Department of Planning and Environment

Our ref: DOC22/240120
Your ref: SSD 30923027

Subject: Compass 2 Warehouse & Distribution Centre (SSD-30923027)

Figure 8: Landscape Masterplan

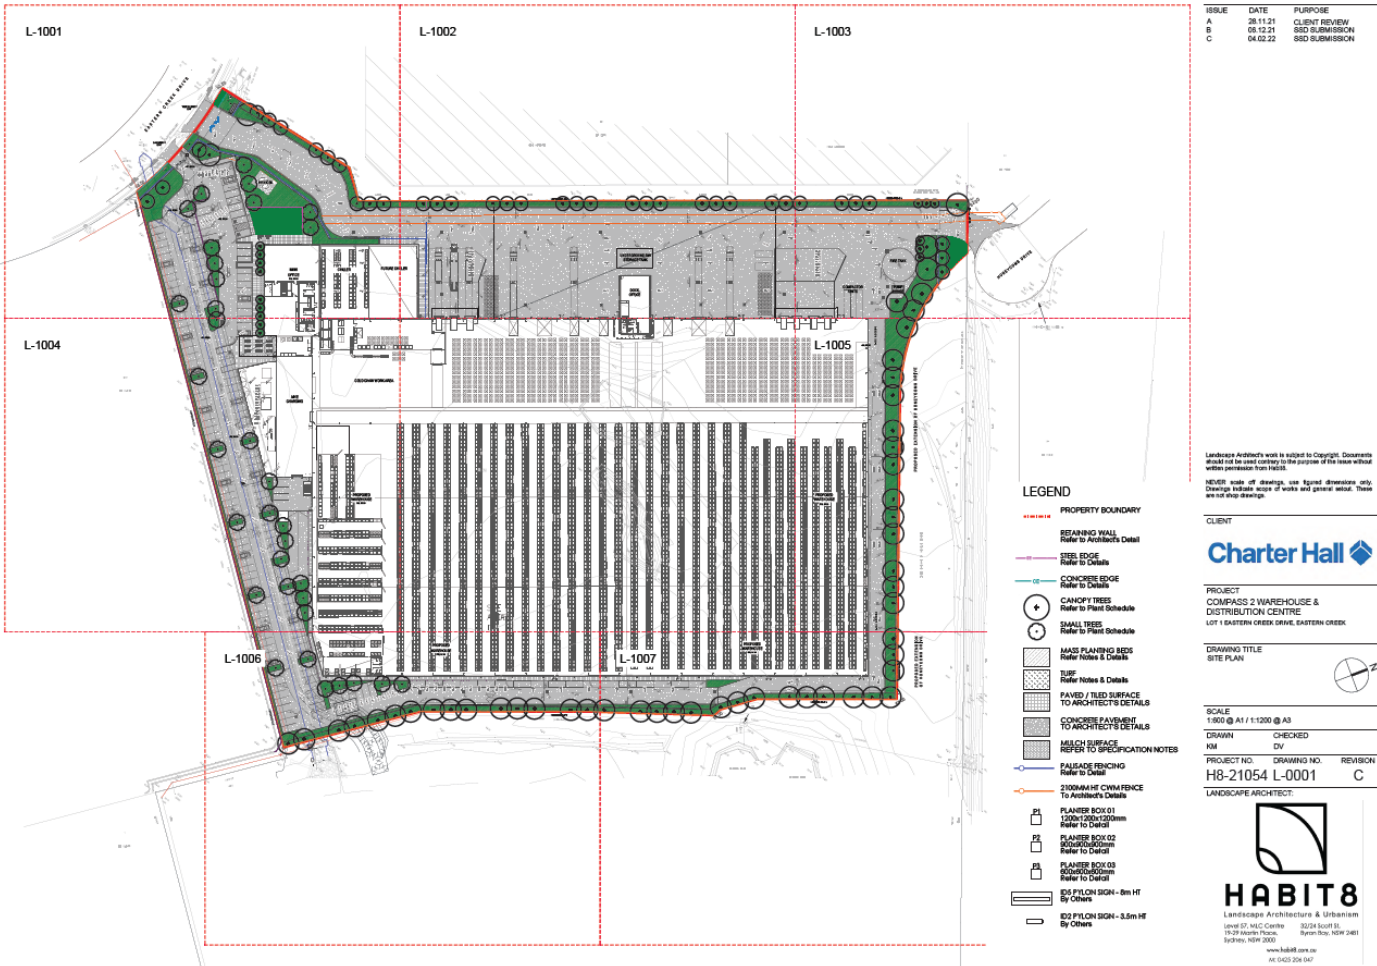
Proposed landscaping will play a role in replenishing biodiversity values on the site and reducing heat island effects arising from the development. EHG has undertaken a review of the landscape plan prepared by Habit 8 dated 11/02/2022 and notes that there are discrepancies between the planting schedule and planting plan which should be rectified. Specifically, proposed plantings of *Eucalyptus moluccana* are incorrectly identified as *Eucalyptus ovata* on the planting plans. References to *Eucalyptus ovata* should be amended to *Eucalyptus moluccana*.
